Response to Supplementary Matters raised by DP&E

No.	Issue Raised	Proponent's Response
	Supplementary queries arising from DP&E community engagement – Email of 3 September 2018	
	Impacts of intensification of usage	
DPE37	<p>The proposal would result in the intensification of usage of the site in terms of the proposed number of events during each year. The increase in the frequency of the events would result in the usage of Moore Park as a car park more often. This is considered to be an adverse impact on the availability of parklands in the area for the purpose of community use. Further, the intensified use of Moore Park as a car park would result in further degradation of the park.</p> <p>In regards to these increased impacts what strategy can be developed to address the questions future intensification of usage on Moore Park?</p>	<p>There are currently no restrictions on the number of events that can be held annually at SFS, apart from concert events. Since its opening in 1988, the SFS has had at least 7 years with annual events greater than 50, with a peak number of 55 events occurring in 1992. As such there is no increase in intensity compared to existing operations based on

8.12 Shadow Diagram - 10am (21 June)

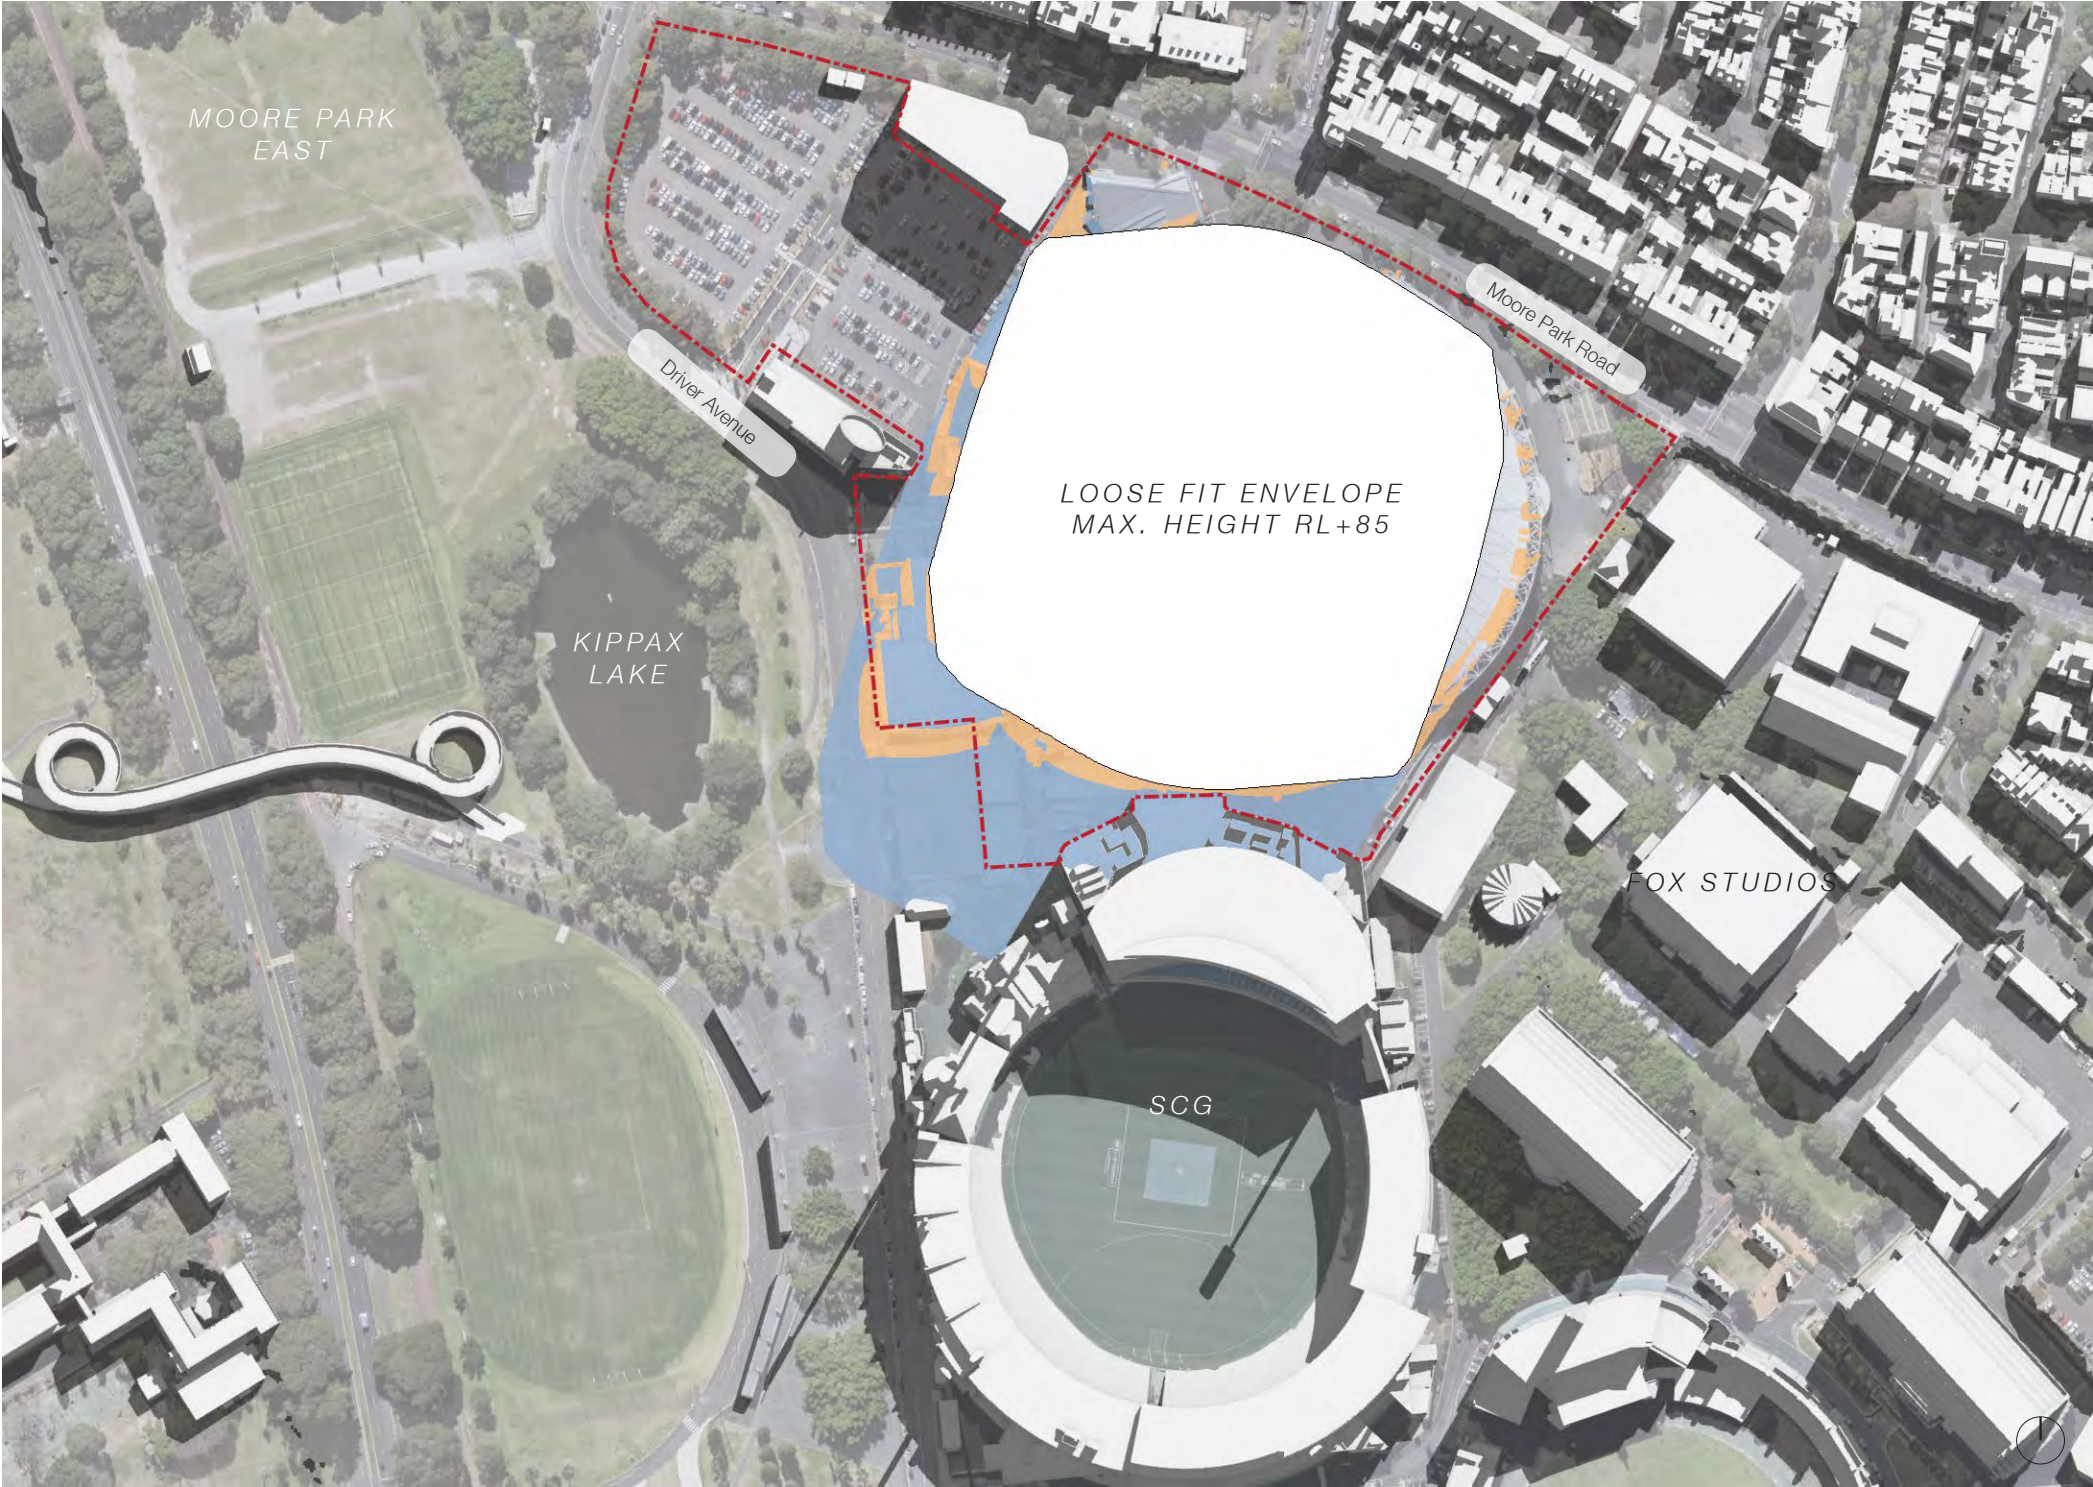
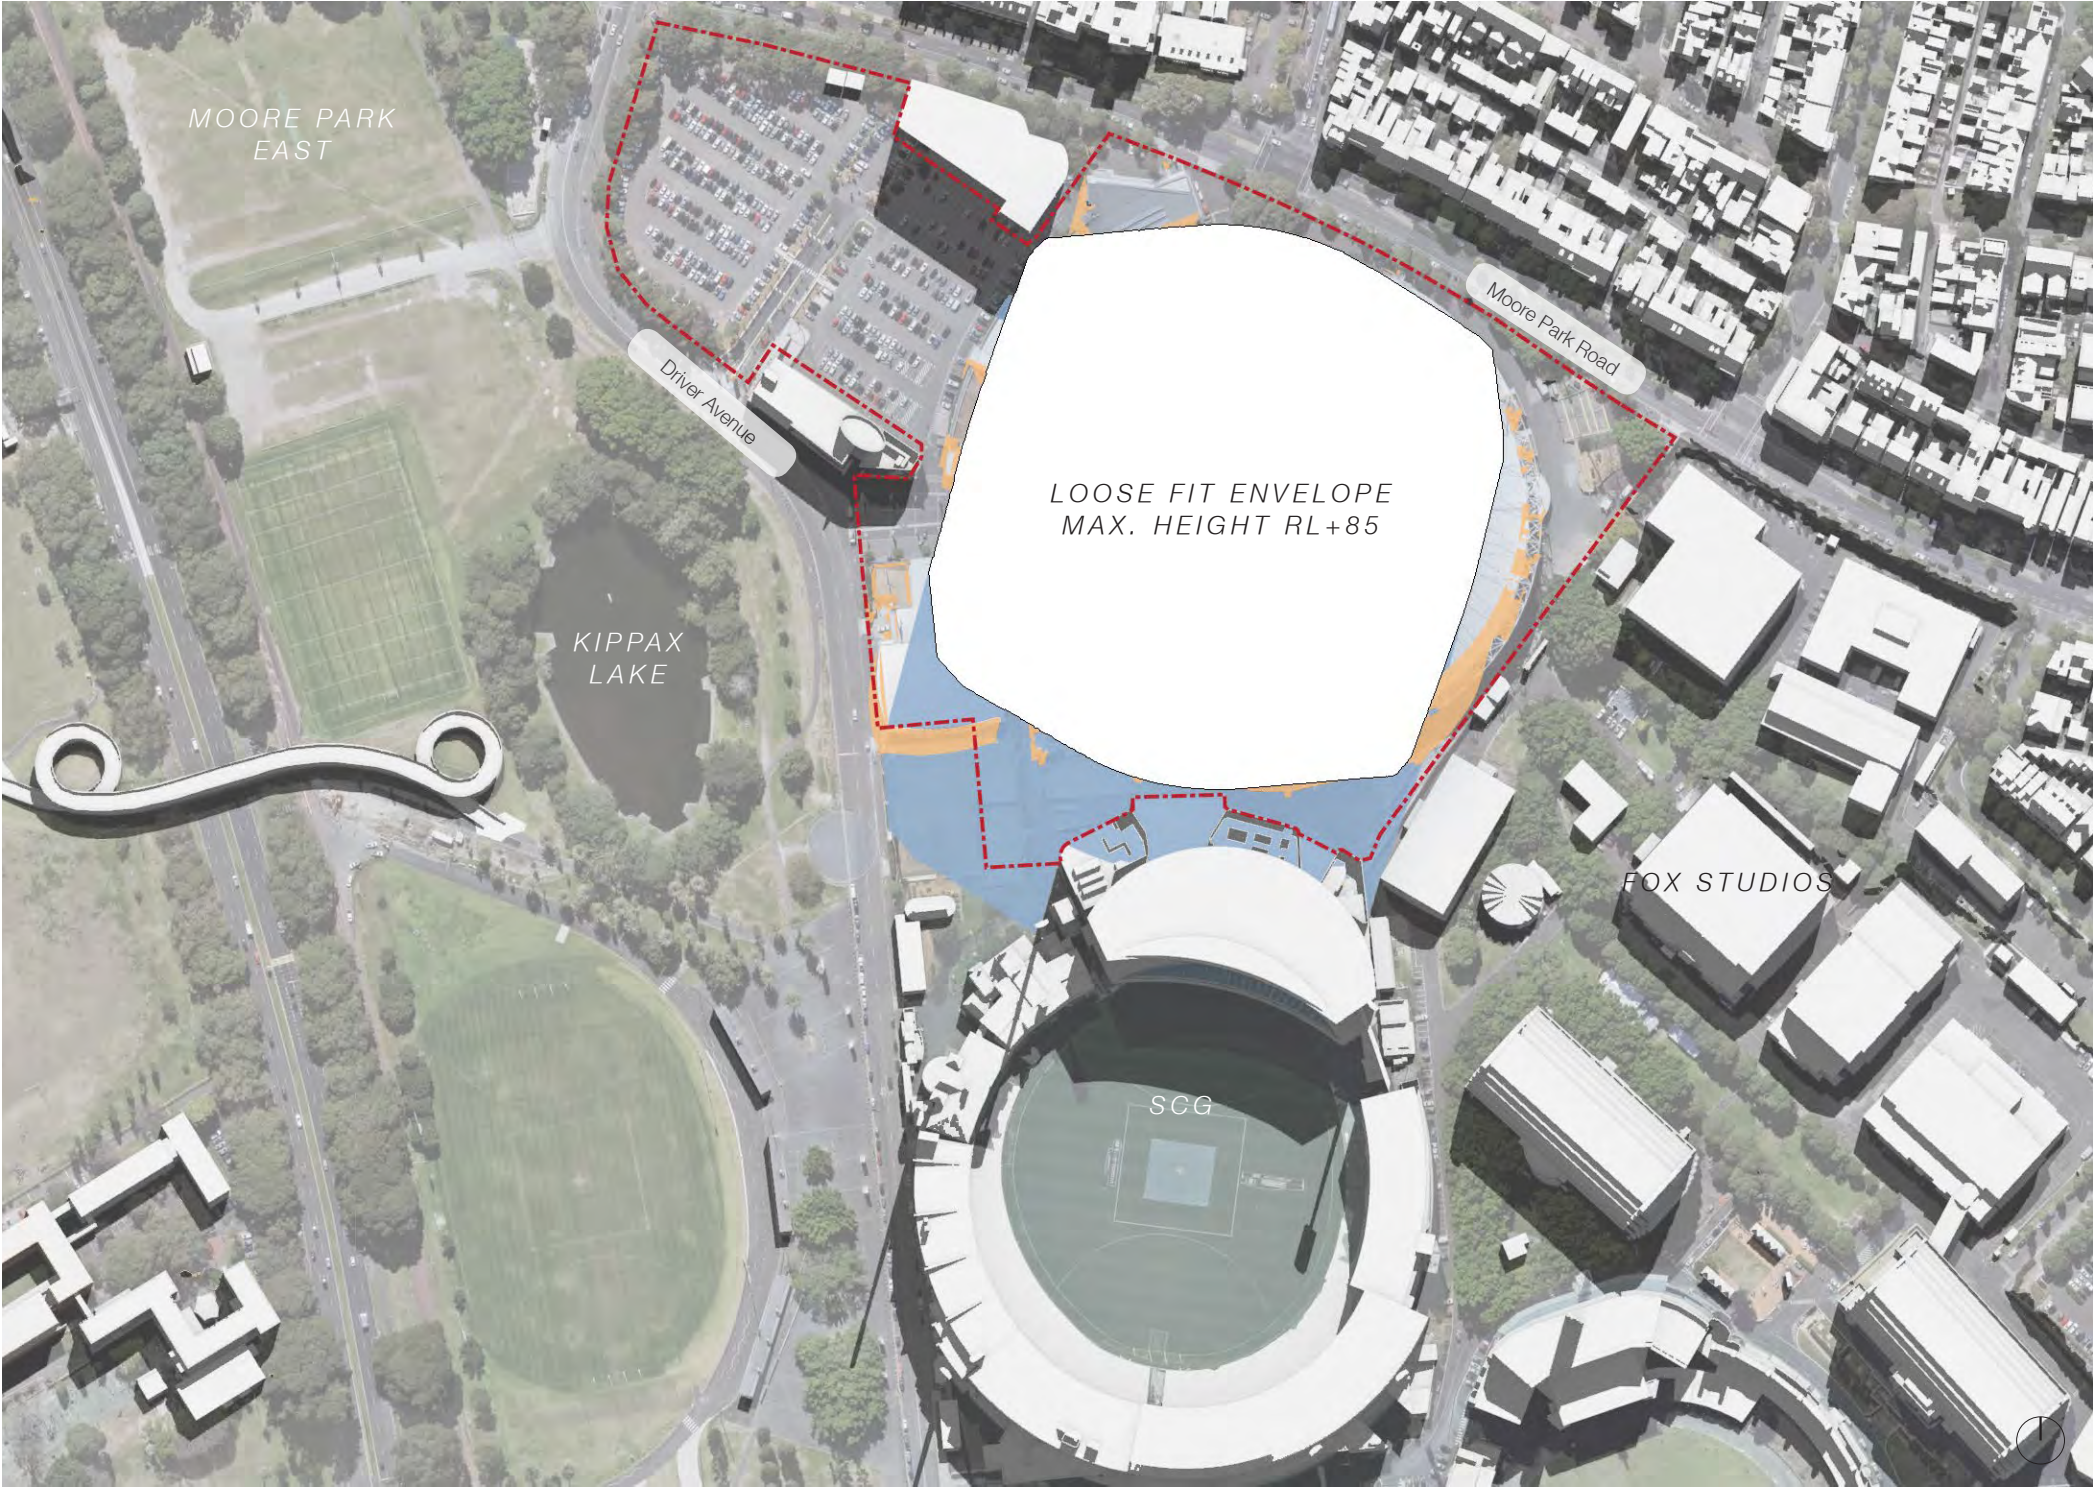
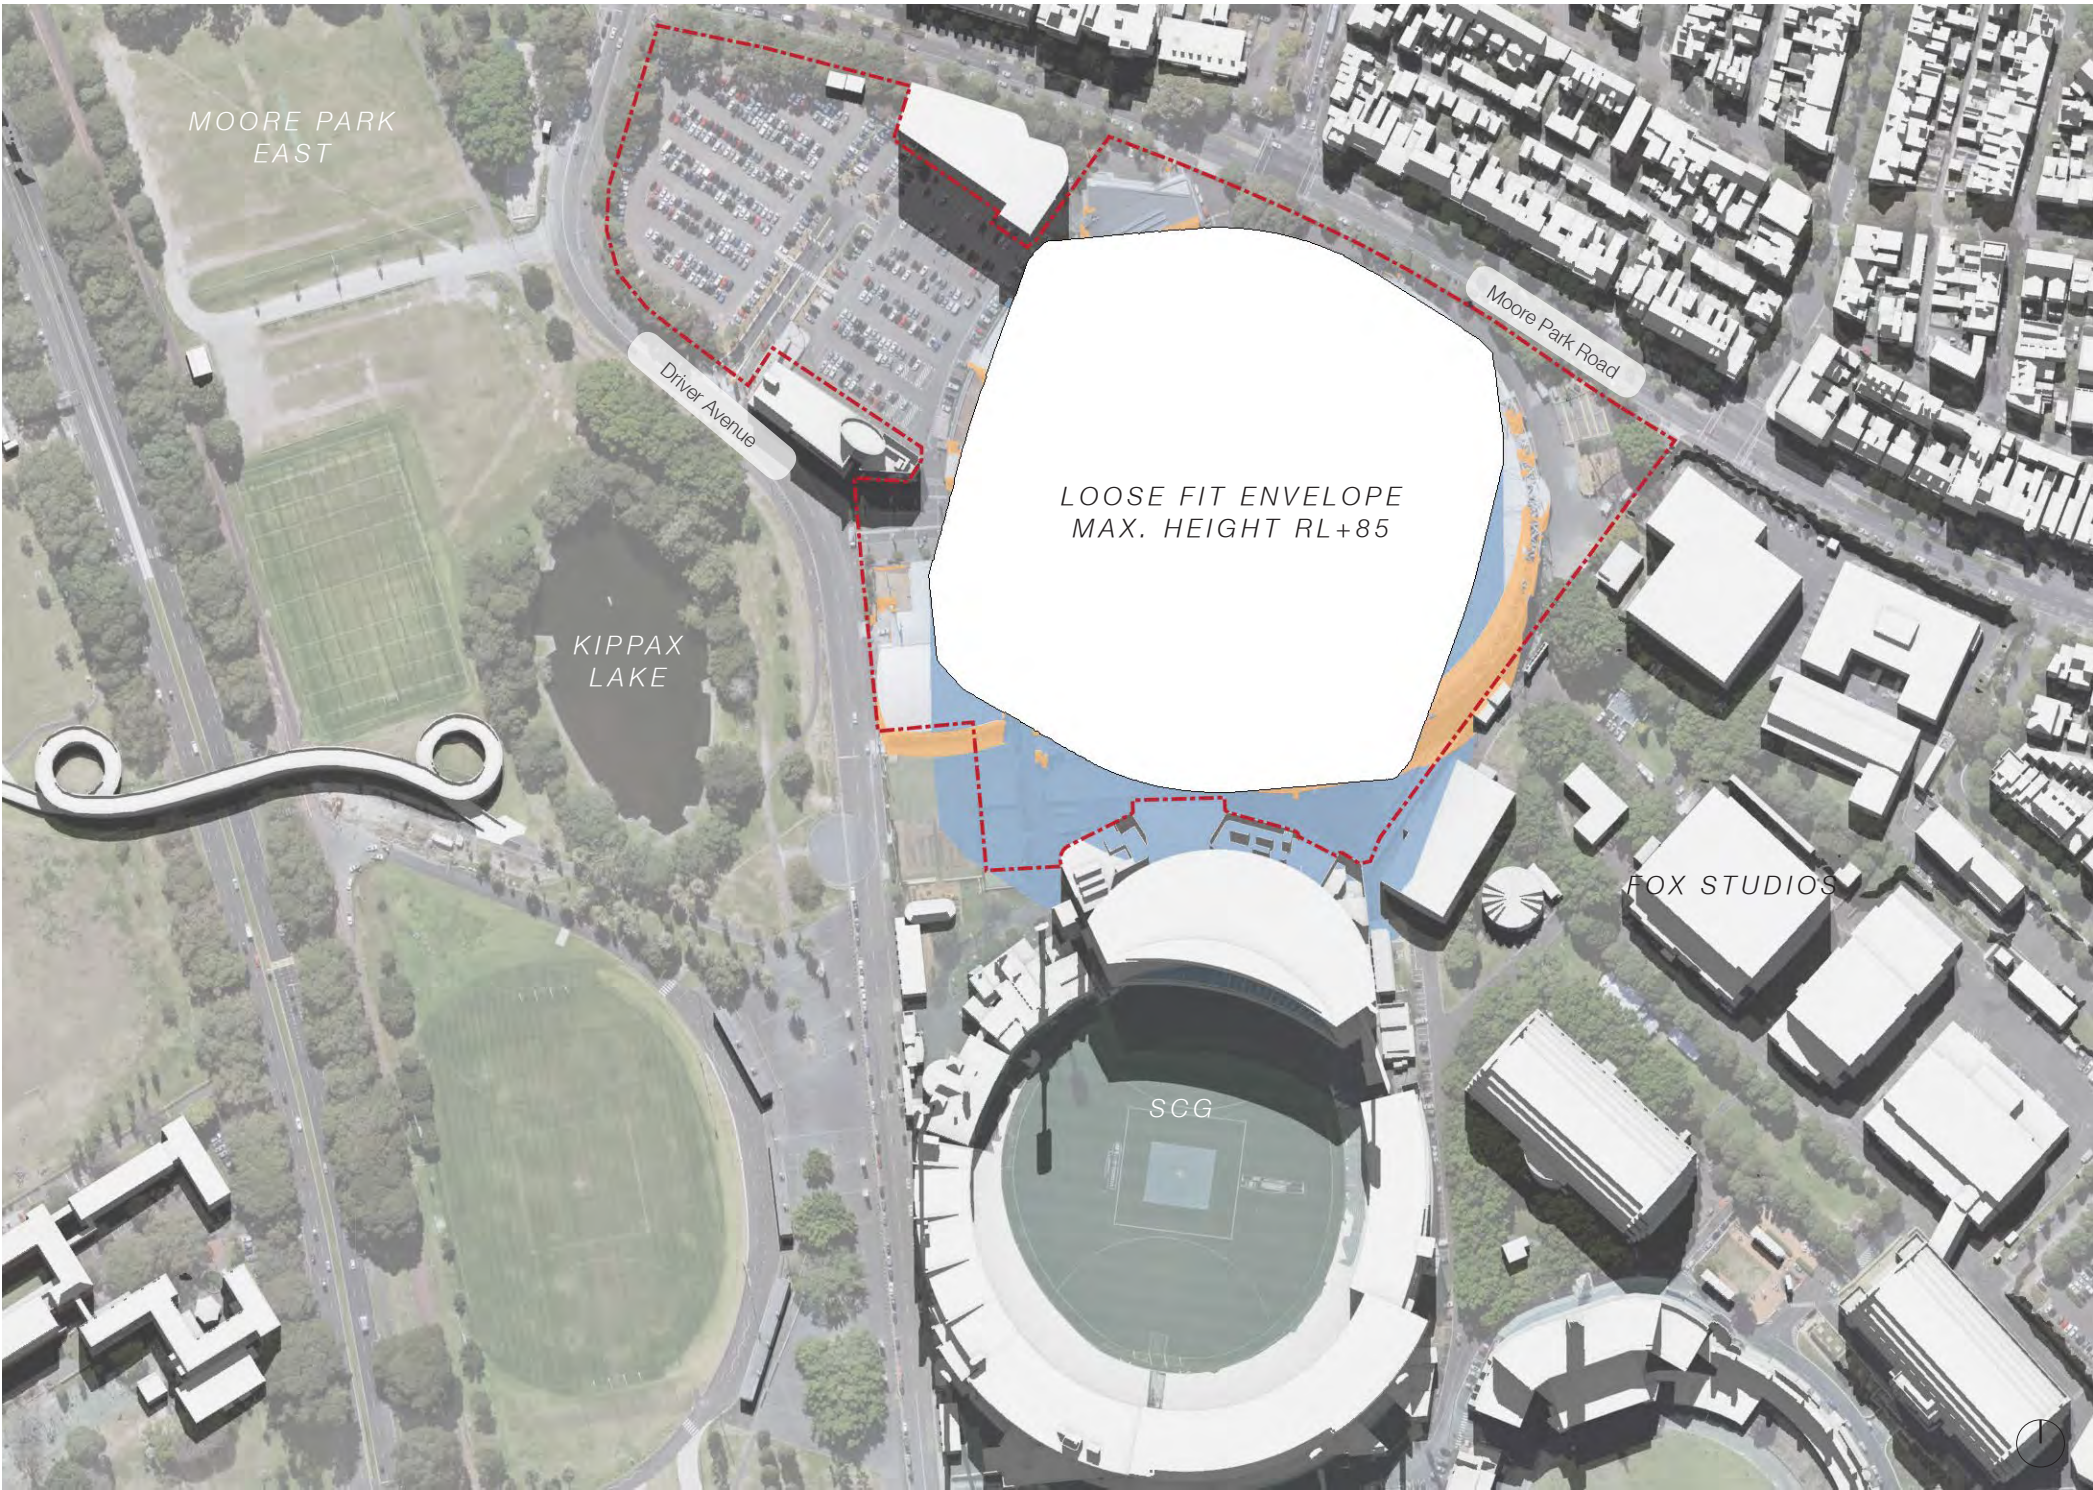
Shadow diagrams	
DPE45	The Shadow diagrams do not clearly show, describe or reflect the impact on Kippax Lake or Poate Road.	As illustrated in Attachment 4 of the Response to Submissions, there will not be any overshadowing of Kippax Lake or Poate Road between 9am and 3pm at mid-winter.
	Adverse Impacts of Demolition	
DPE46	The existing stadium may contain asbestos. In this regard, has Hazardous Materials Survey being conducted? If yes, then can the details be provided?	A Hazardous Materials Survey will be completed prior to the commandment of demolition works. Refer to Mitigation Measure S1-CG1 in the Final Mitigation Measures at Section 5.0 of the Response to Submissions.
	Community Consultative Committee (CCC)	
DPE47	The opportunity to create a CCC prior to the determination of this application is not constrained by the Department. Can INSW start this process?	The <i>Community Consultative Committee Guidelines</i> (DP&E, 2016) states that, if the Department decides a CCC is warranted, it will require the Proponent to establish the committee either through the SEARS (which is not the case for this project) or following approval through the conditions of approval for the project. Accordingly, the Applicant will establish a CCC at the time of approval if required by DP&E. It is understood that DP&E may require a CCC to be established prior to determination of the project. The Applicant has no objections to this.
